Recommendation Report for Works to Tree(s) on trees subject to a Tree Preservation Order (TPO)

REF NO: AW/70/19/T

LOCATION: Holly Lodge  
3 Barrack Lane  
Aldwick  
PO21 4BY

PROPOSAL: Crown lift by 1m, Crown reduction by 3m & Crown thin 30% to 2No. Holm Oak trees.  
Crown reduction by 3m & Crown thin 30% to 1No. Sycamore tree.  
Reduce split bough by 2.25m to 1No. Holm Oak tree.

LOCATION PLAN.

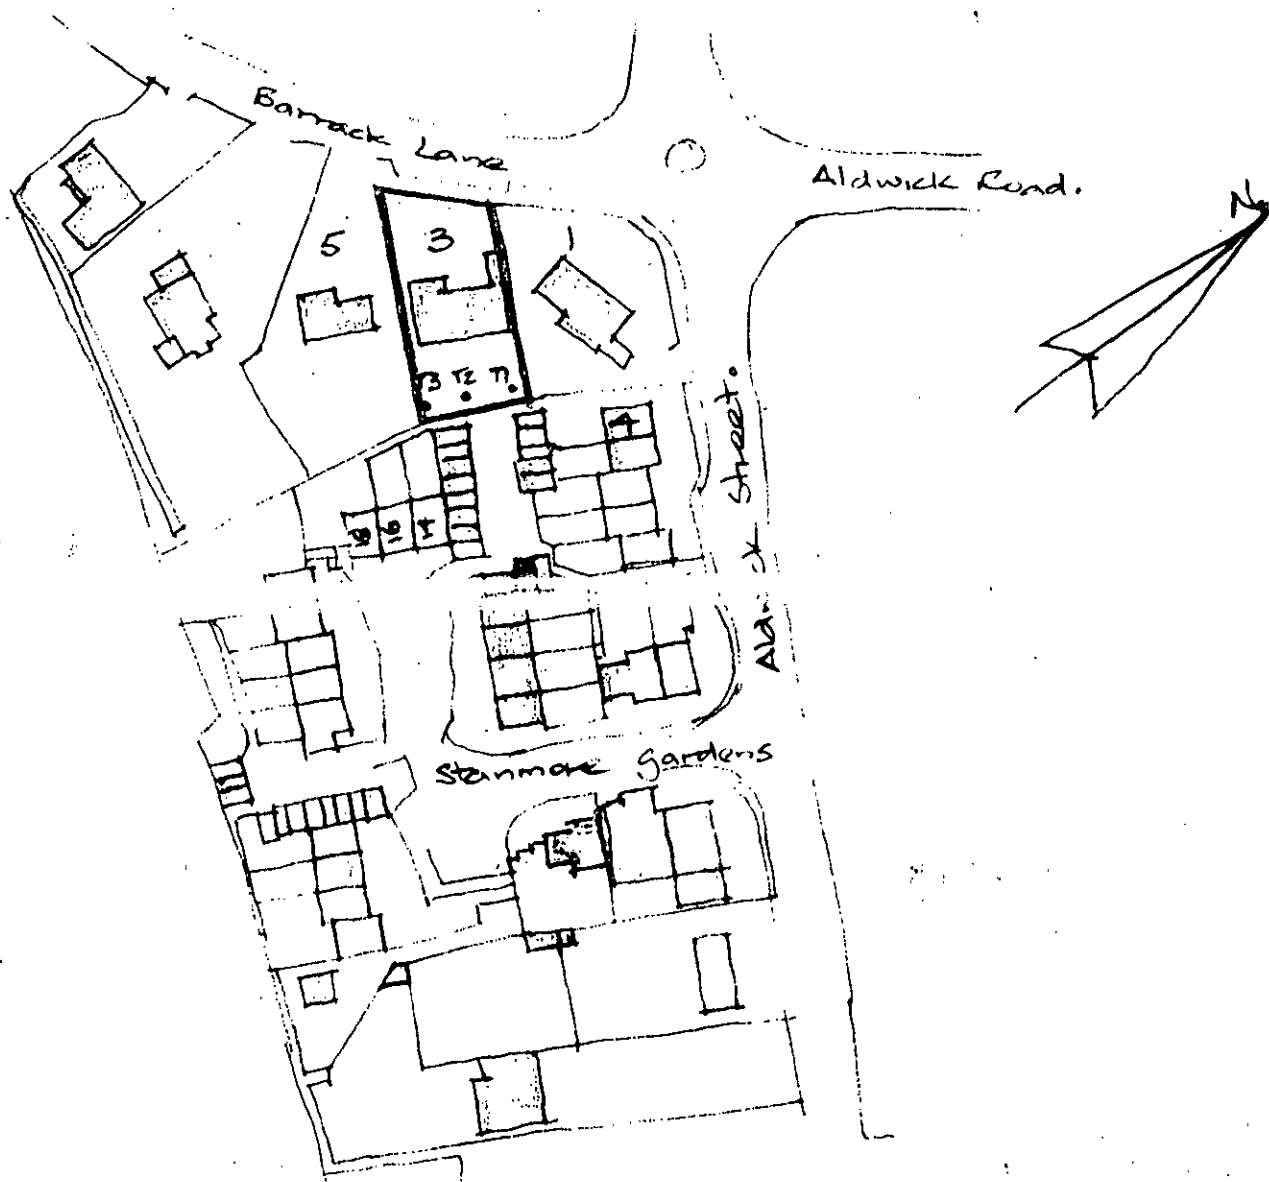
Tree Officer Comments: T1 & T3 Holm oak / Quercus ilex Average height: 8m Average spread: 3m

T2 Sycamore / Acer pseudoplatanus Approx. height: 10m Average spread: 3m Age class:

- Outwardly and from a distance they appear to be healthy and stable. Despite their history of heavy and regular crown reduction they have 'grown-on well' (particularly T2) and their collective canopy makes a useful visual contribution. Canopy height, spread and overhead clearance is proportionate and not obviously problematic in relation to its surroundings.

- I did not observe a split limb/branch although my view was restricted to the eastern aspects. If such a limb presents an immediate risk of harm to person/property then it would qualify as an exception and does not require our consent prior to it being 'made safe'.

- Crown reduction and Crown thinning work has not been justified on arboricultural grounds. In respect of the latter, such work rarely provides a benefit to the tree and often only a short-term increase in light levels. Furthermore, such considerable loss of crown volume during a one-off operation will impose undue physiological distress and may compromise their long-term position in the landscape.

- I recommend REFUSAL for this application.

- 1 The timing of this latest proposal is premature in the management cycle and likely to be harmful to the trees ongoing health and vitality. There is insufficient extension of new growth since the last major pruning operations (c2015)
- 2 INFORMATIVE: It is recommended the applicant re-apply for the crown lifting and crown reduction elements of this application in 18-24months from now, at which time I would expect the subject trees to have achieved sufficient canopy renewal to sustain repeat operations.
